TRANSPORTATION MEMORANDUM

Sunflower Landscapes
El Paso County, Colorado

PCD File No: VA265 Added

June 2026

A site plan, as prepared by Sunflower Landscapes, is shown in Figure 2. This plan is provided for illustrative purposes only.

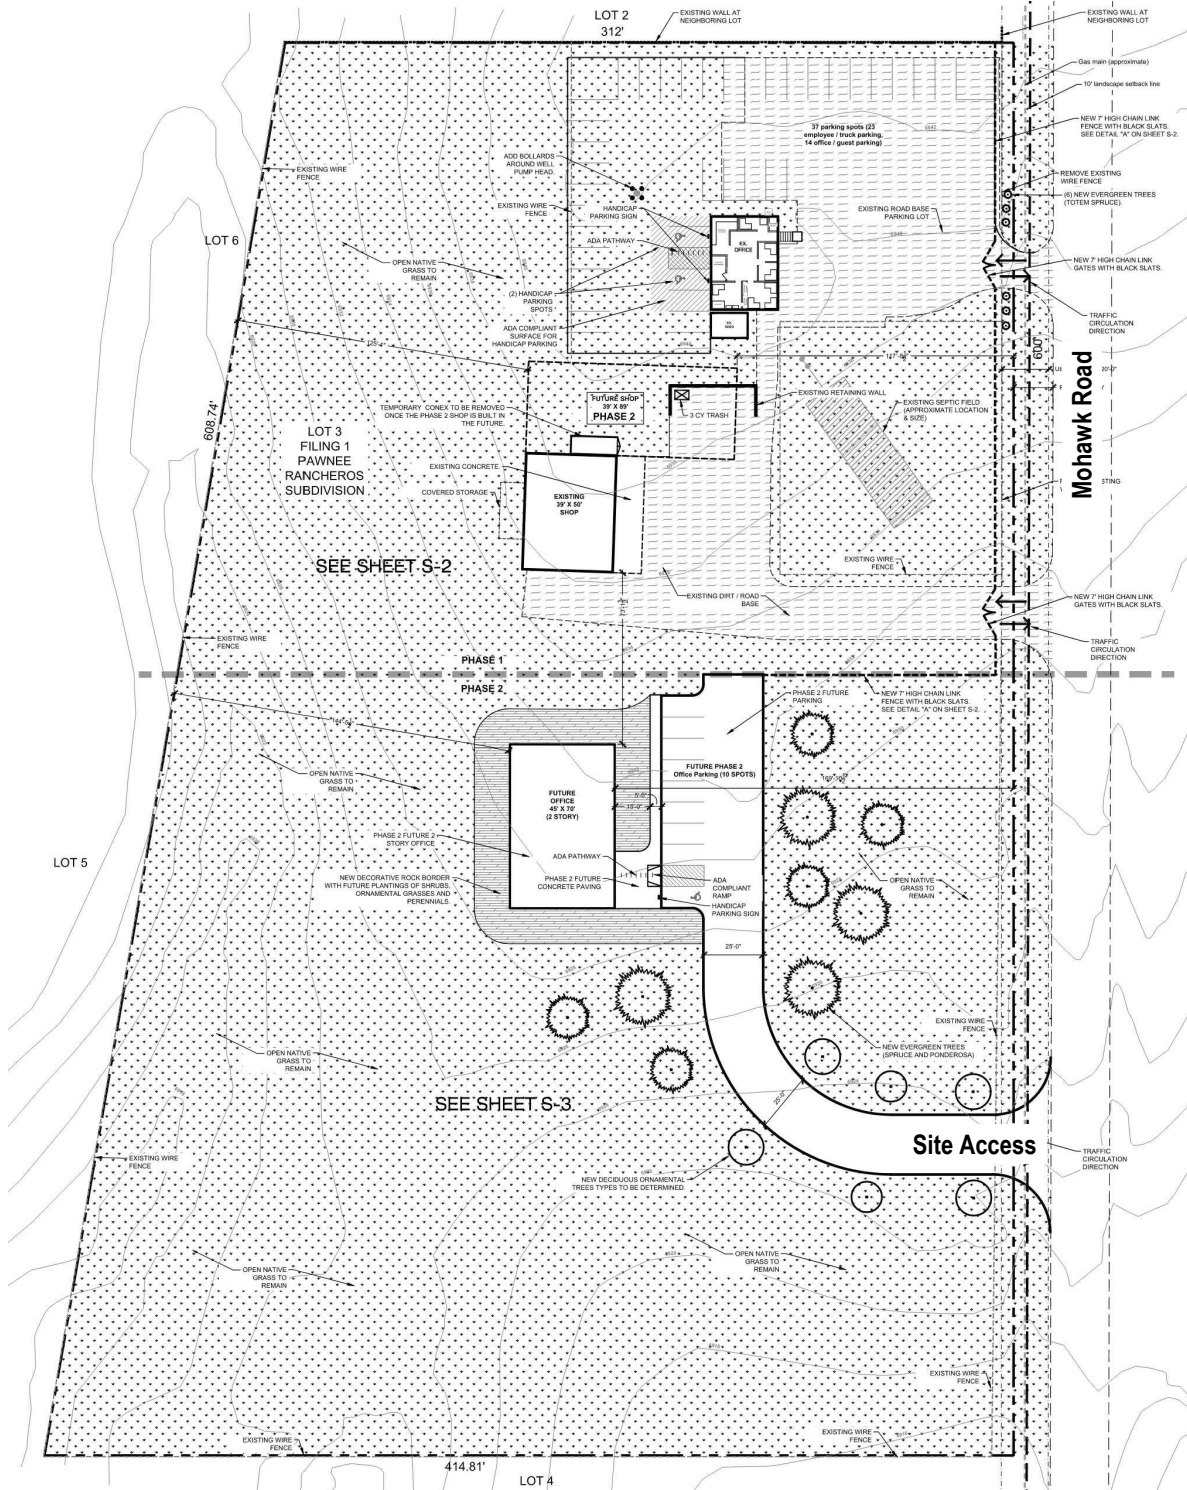
The description of the proposed access points does not match what is shown on the current site plan. The site plan depicts the existing access and a proposed access near the north side of the property; however, no access is shown across from the school driveway as described in the narrative. Please revise the site description and access-point analysis so they accurately reflect the access locations shown on the current site plan drawing.

Figure 4
BACKGROUND TRAFFIC - YEAR 2028
Volumes & Intersection Geometry
AM / PM Peak Traffic Hour
(ADT) : Average Daily Traffic

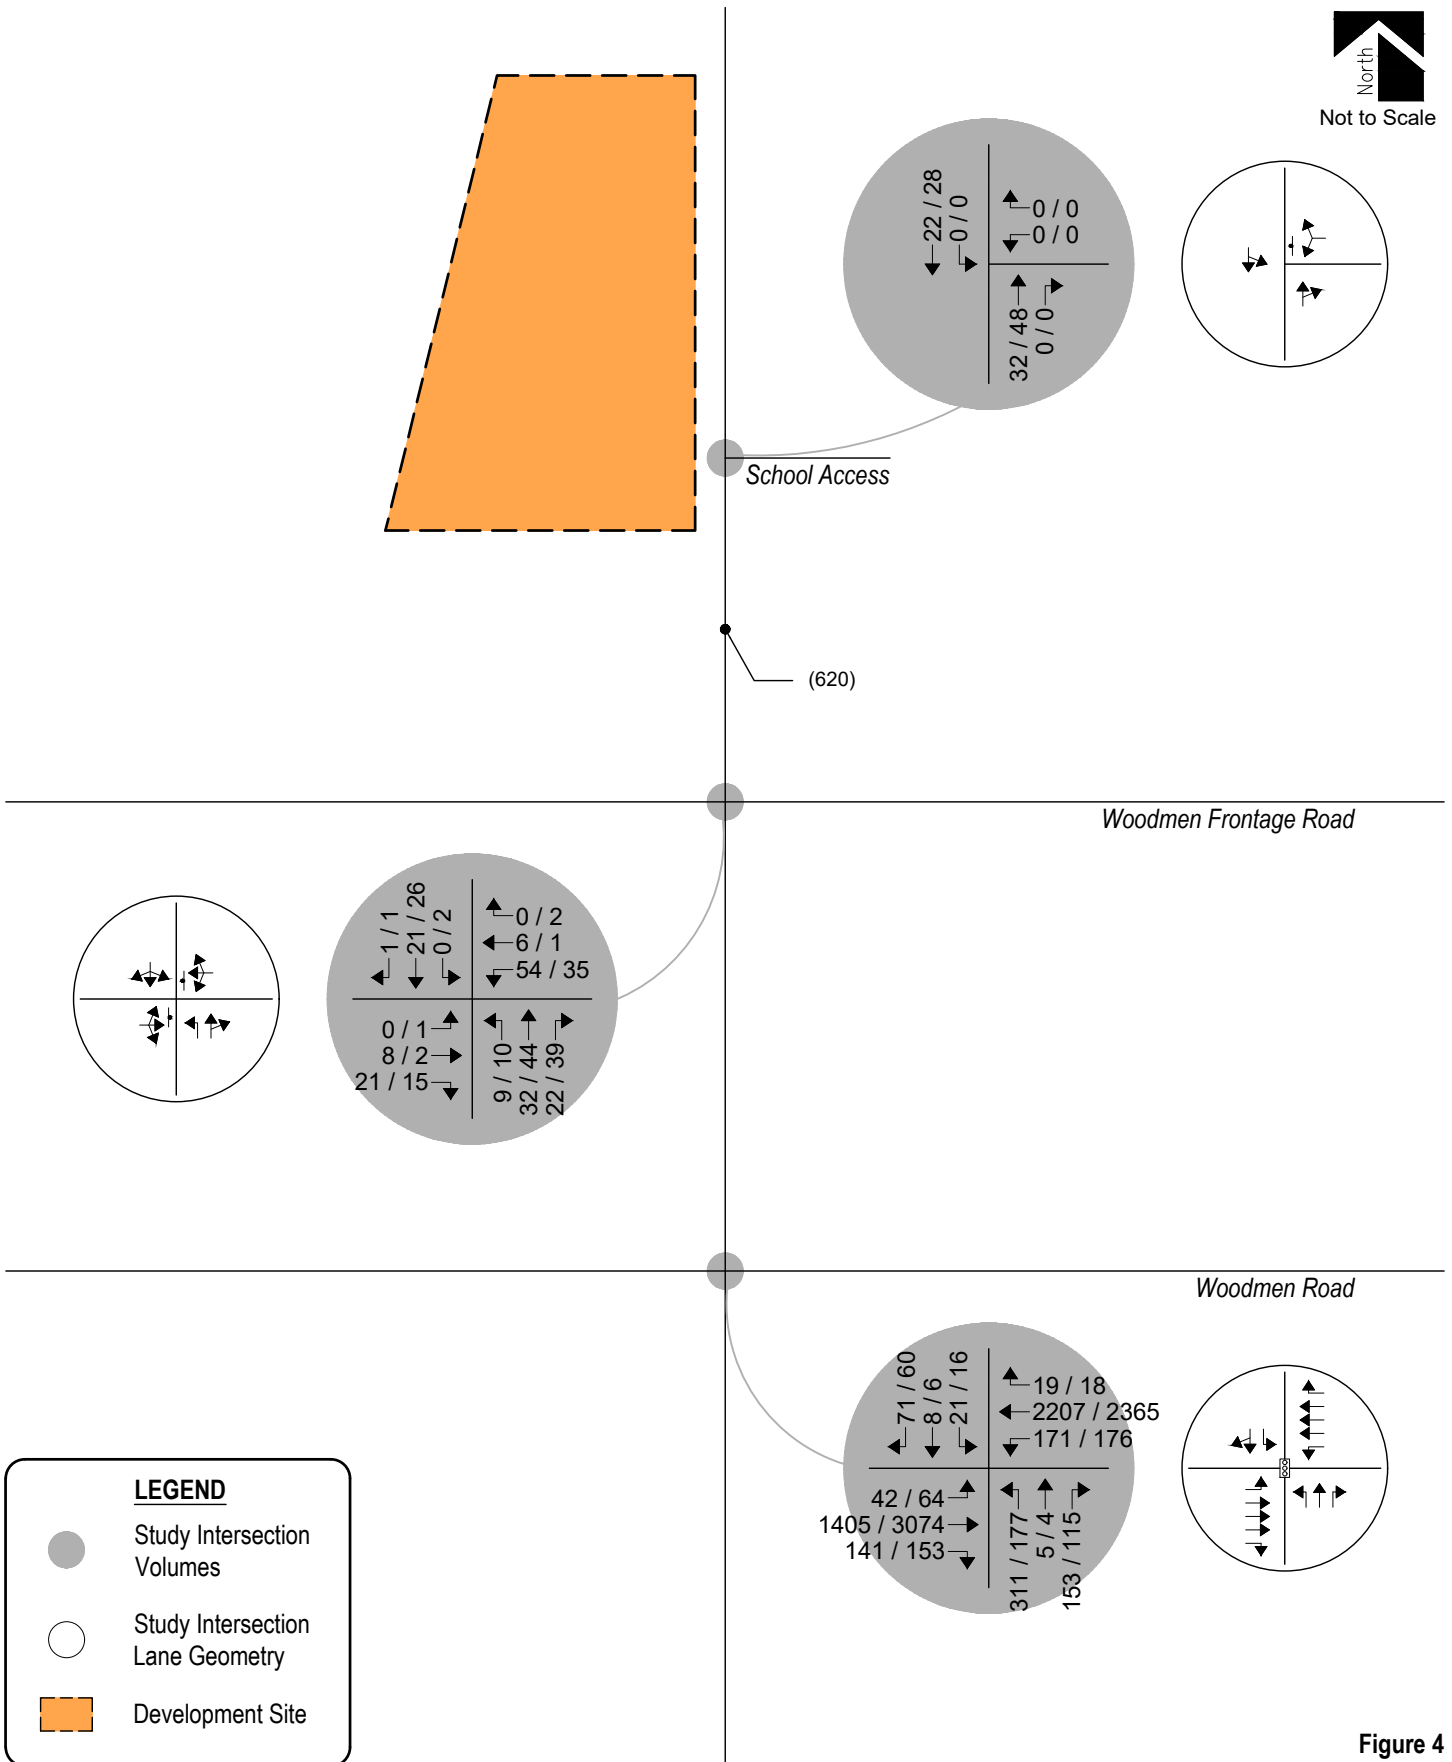
The soccer complex south of Woodmen Road is not mentioned in the narrative. Please include in the analysis and narrative.

Please clarify review comment. Note that this is the Background traffic section of the traffic study, and the soccer complex south of Woodmen Road is an existing use. Therefore, its site-generated traffic is already captured in existing traffic count data.

For verification of future developments, we completed a parcel search in EDARP (and the City's application portal, Accela) to see if the review comment pertains to a future development. We checked both Active projects and Archived projects for all surrounding parcels south of Woodmen Road. We found no information regarding any additional future developments not already mentioned and applied throughout this report.

As such, it is our professional opinion that no revisions are warranted.

Figure 6
TOTAL TRAFFIC - YEAR 2028
Volumes & Intersection Geometry
AM / PM Peak Traffic Hour
(ADT) : Average Daily Traffic

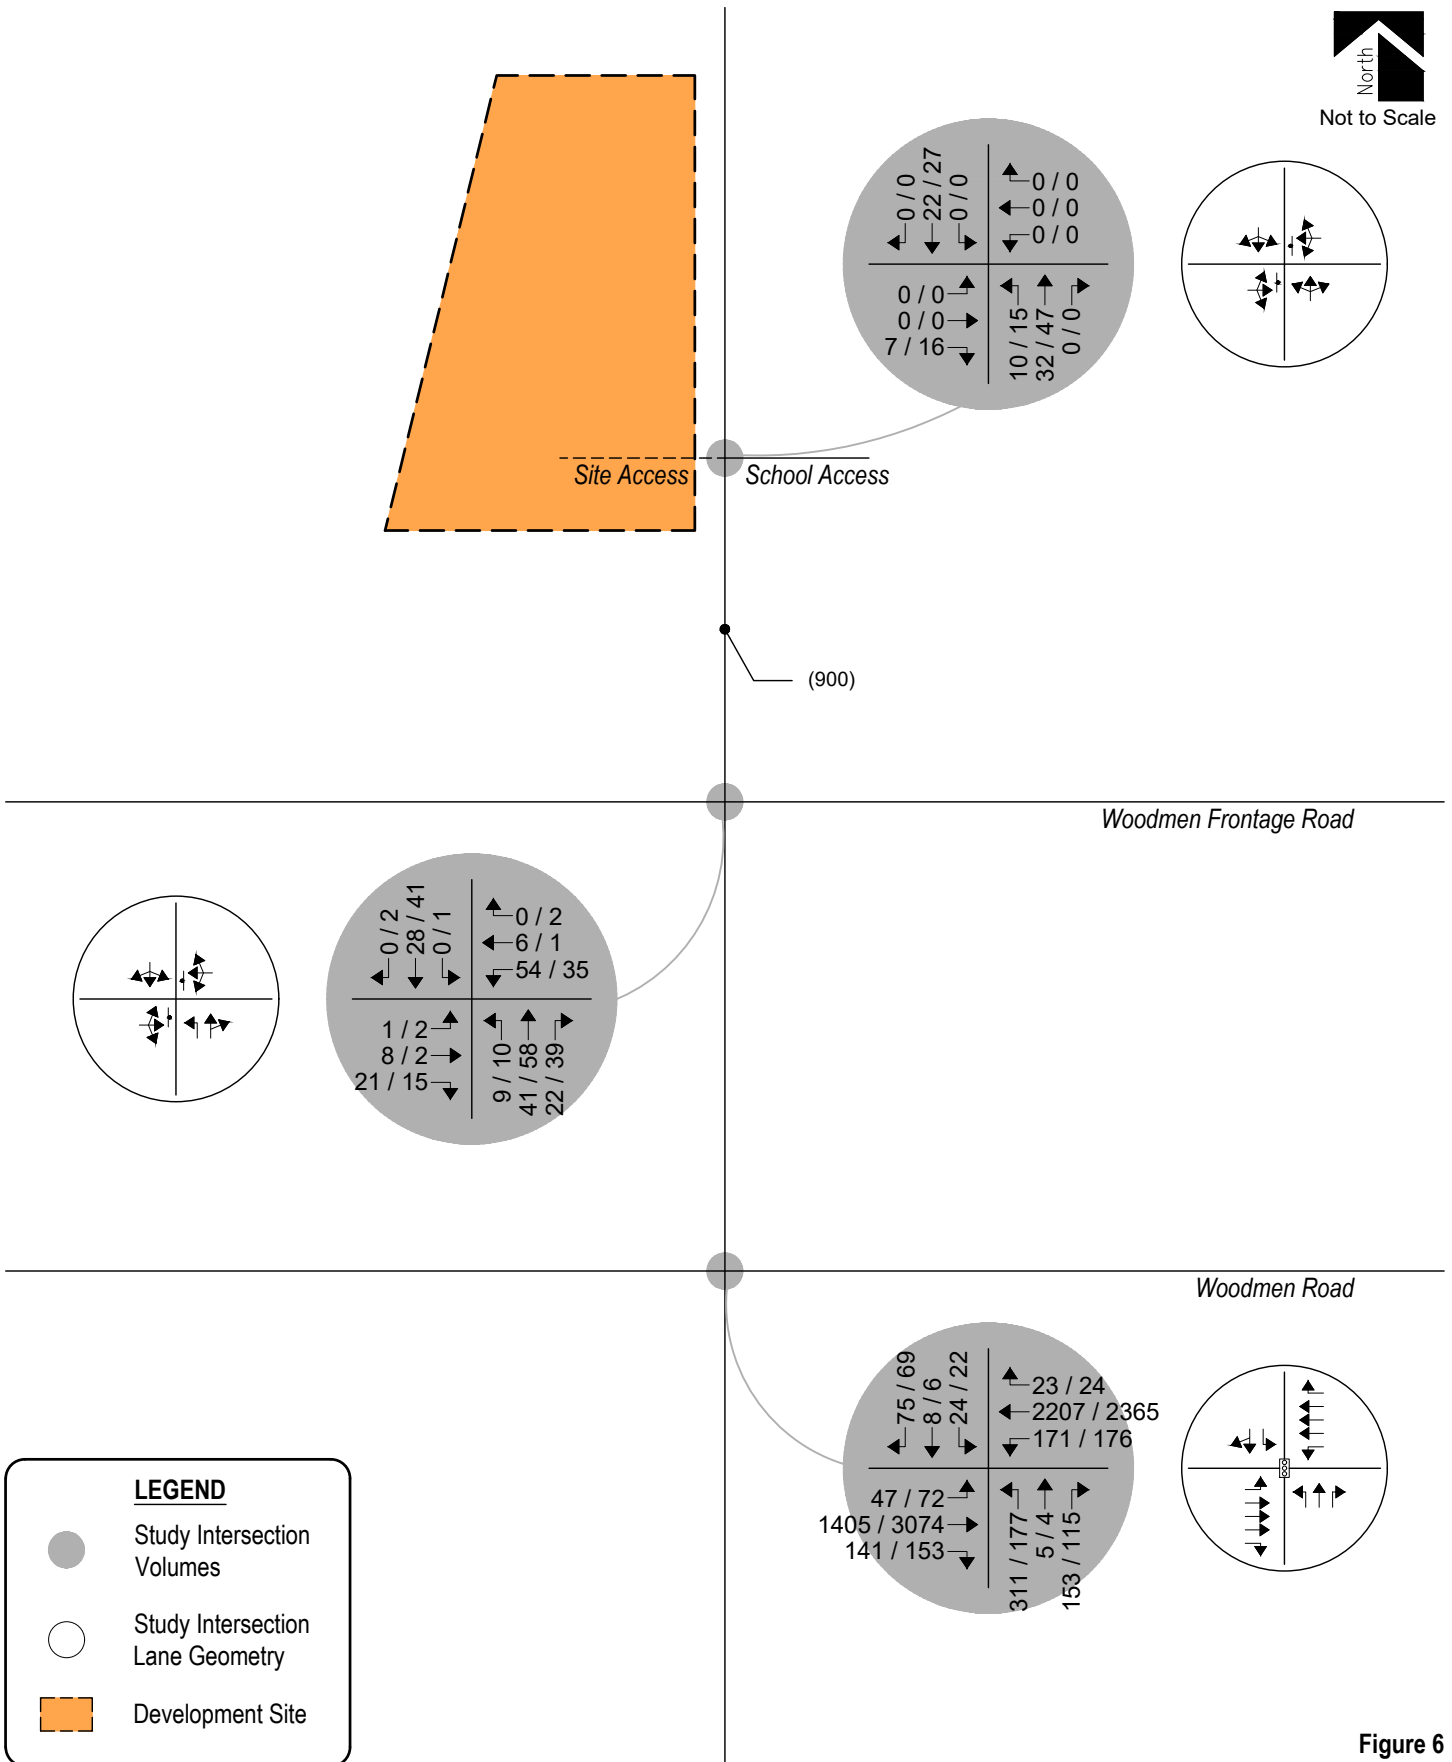
Please include turn lane analysis for the intersection of Mohawk Road and Woodmen Road and state whether the existing turn lanes are adequate.

Exclusive left and right turn lanes already exist for all approaches at Mohawk/Woodmen, so there's no additional auxiliary lane analysis to be had.

Please refer to Table 6 for adequacy of turn lane lengths.

SUNFLOWER LANDSCAPES
Sight Distance Exhibit

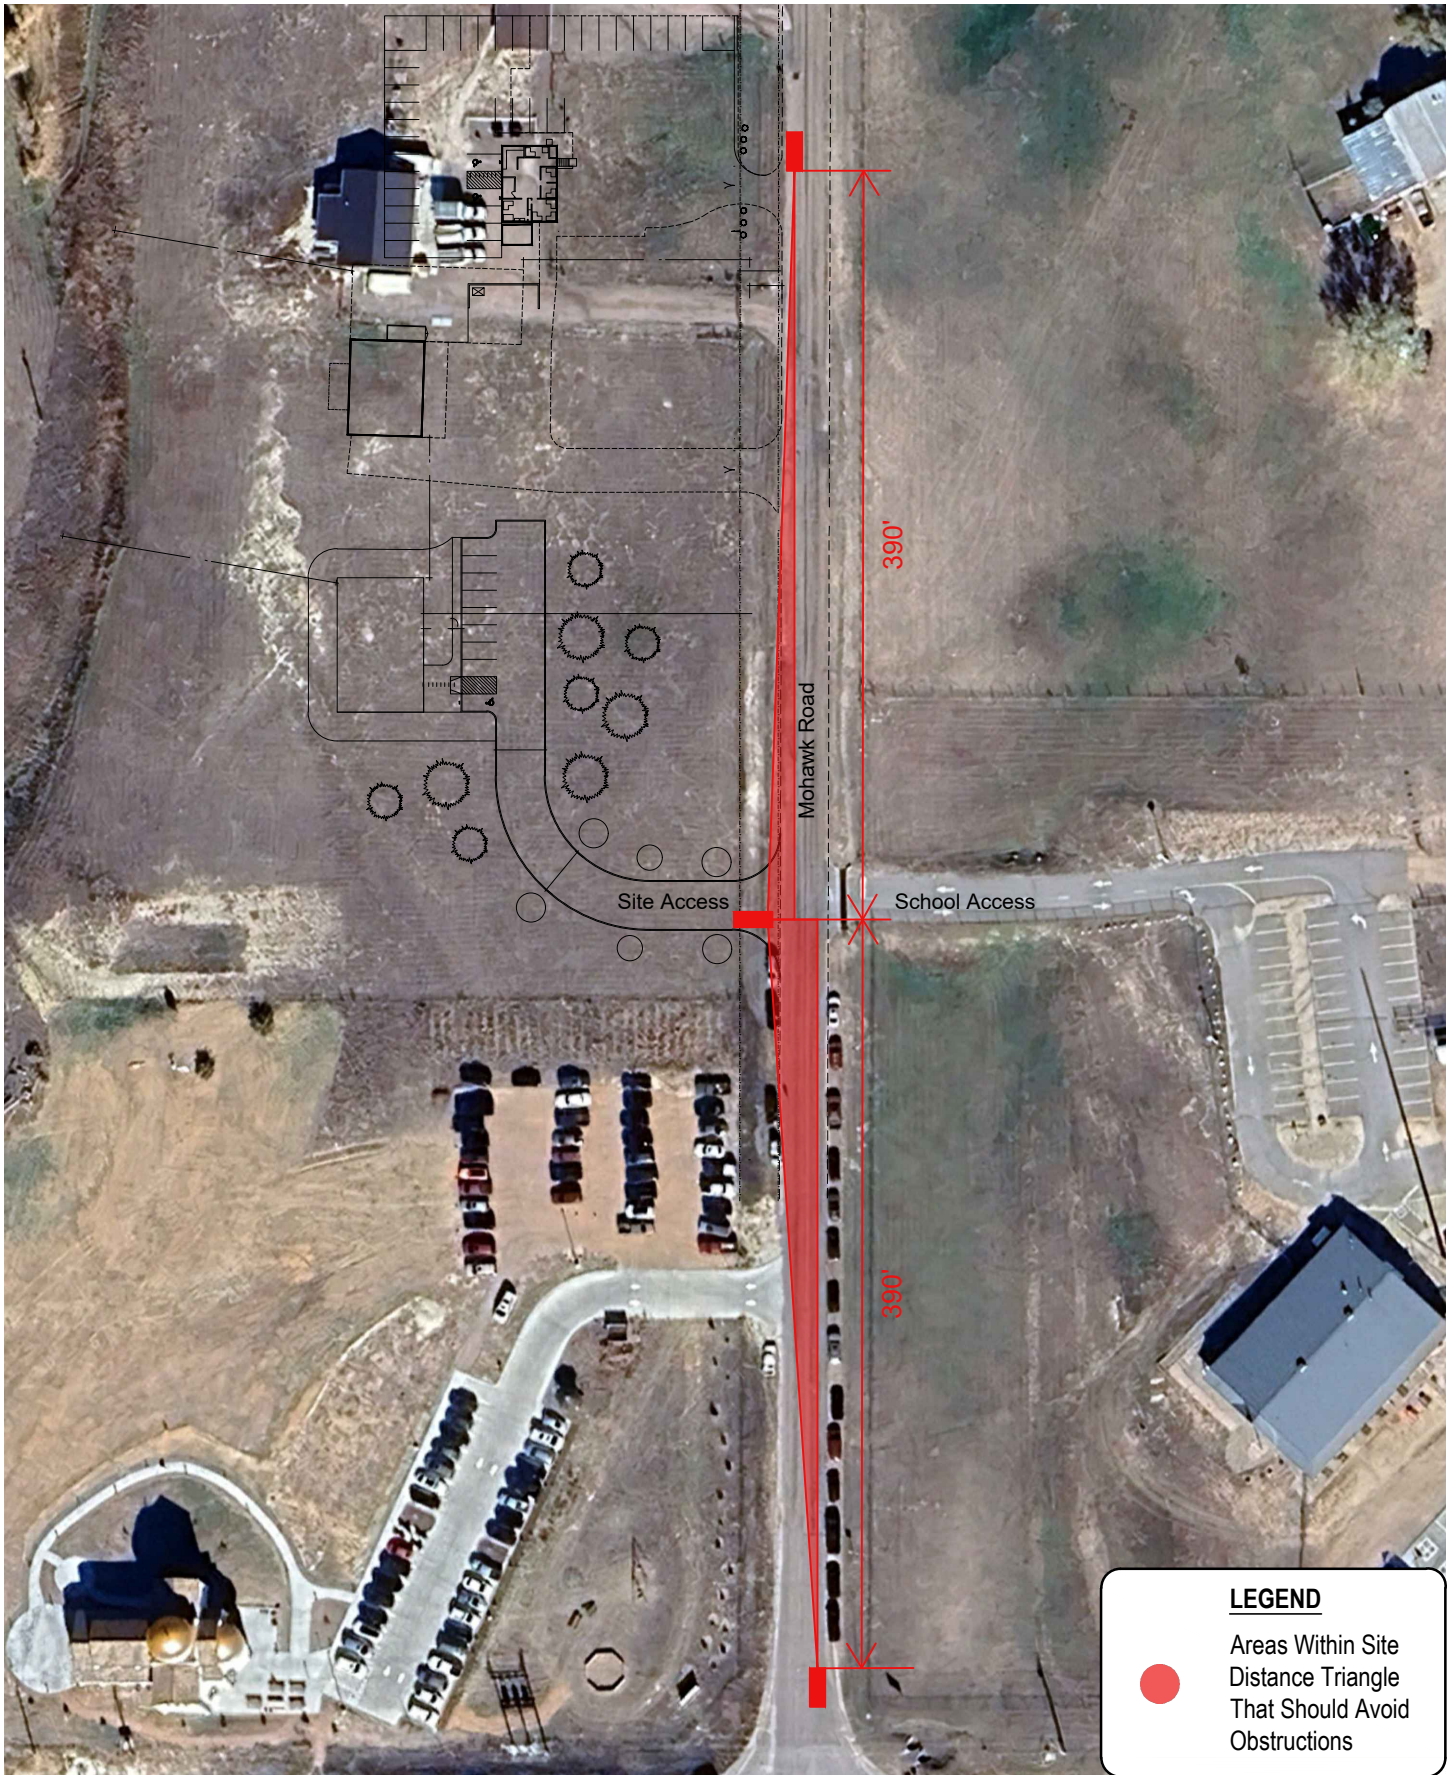
A two-dimensional exhibit does not accurately reflect whether the required sight distance is met, the vertical profile must be considered. A statement must be included whether or not the sight distance is met.

The sight distance analysis may be performed at the site development plan application instead of the variance application. If the applicant is planning to postpone the sight distance analysis, please clearly state that in this report.

Please note the the sight distance analysis shall be reflective of the type of traffic utilizing the site.

The vertical element of sight distance will be provided by the site civil at later stages of development with the construction drawings plan set (typ).
